Mr Timothy Baillie
Director
Bulk Recovery Solutions Pty Ltd
16 Kerr Road
Ingleburn NSW 2565
19/02/2021

**Ingleburn Resource Recovery Facility (SSD-8593)
Request for Additional Information**

Attachment 1

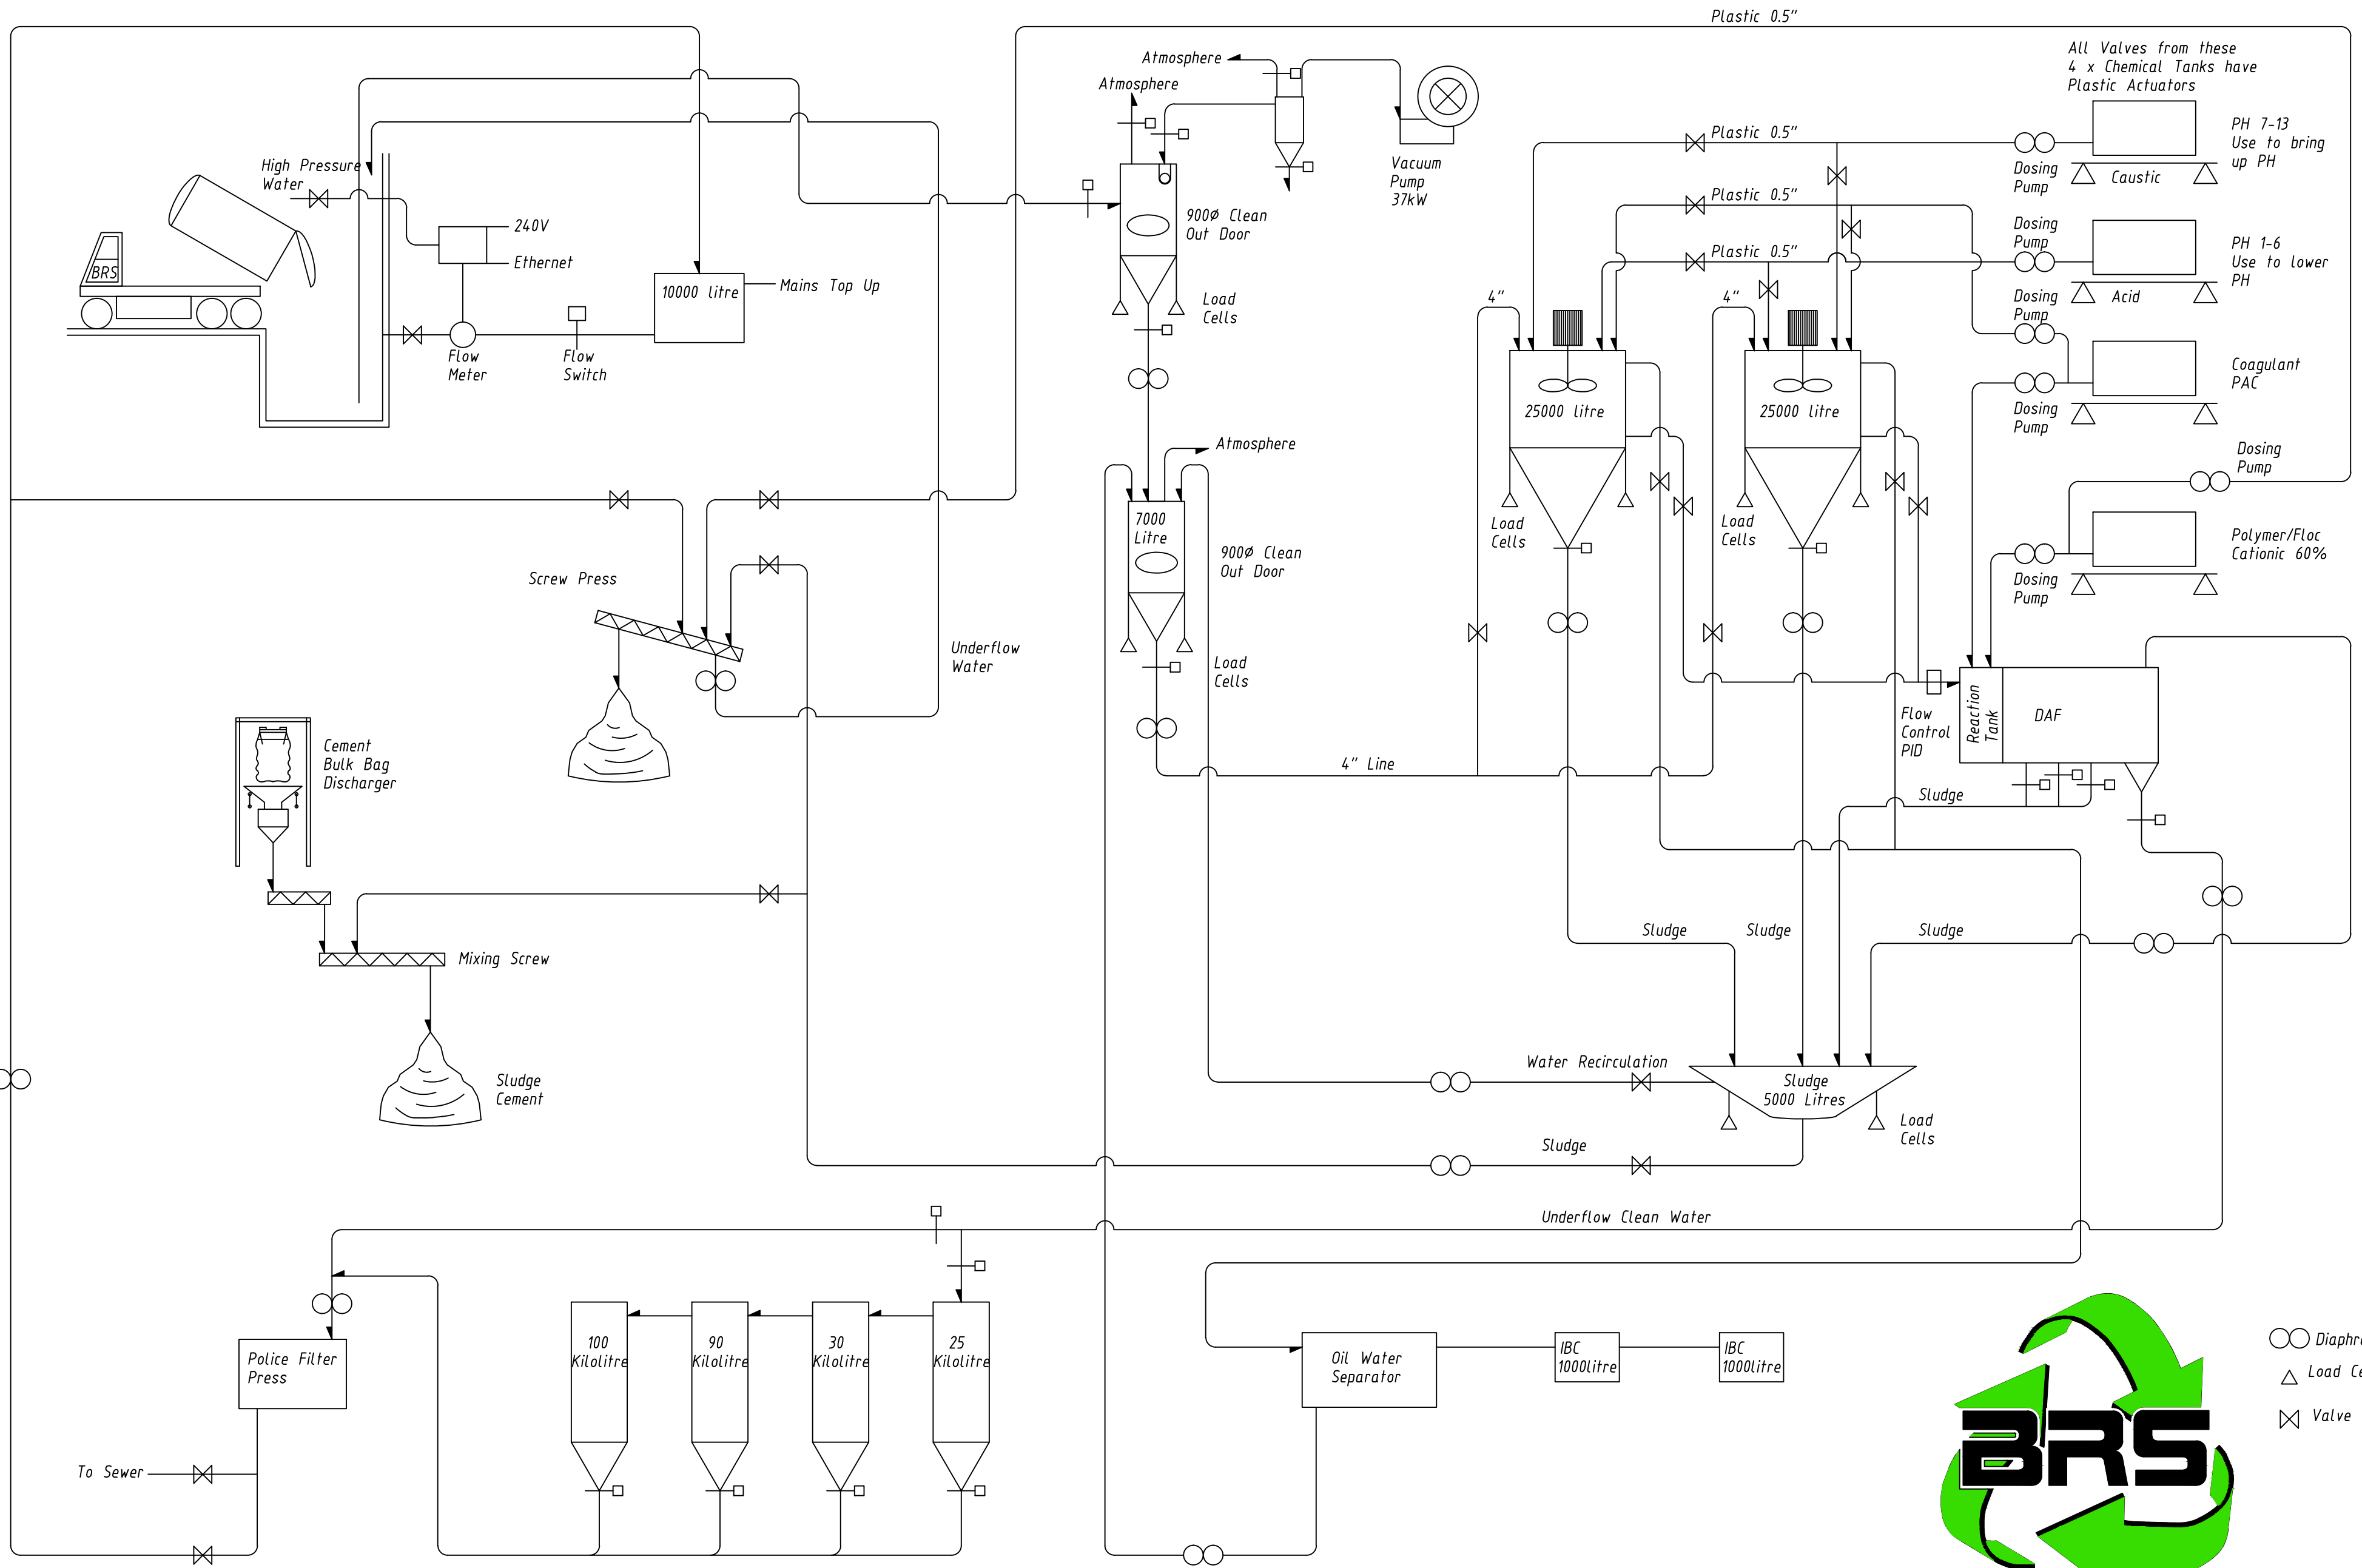
3. An updated process description for liquid waste that matches the proposed equipment list. The existing equipment list and process description do not match the process flow diagrams (see p 32 of the EIS).
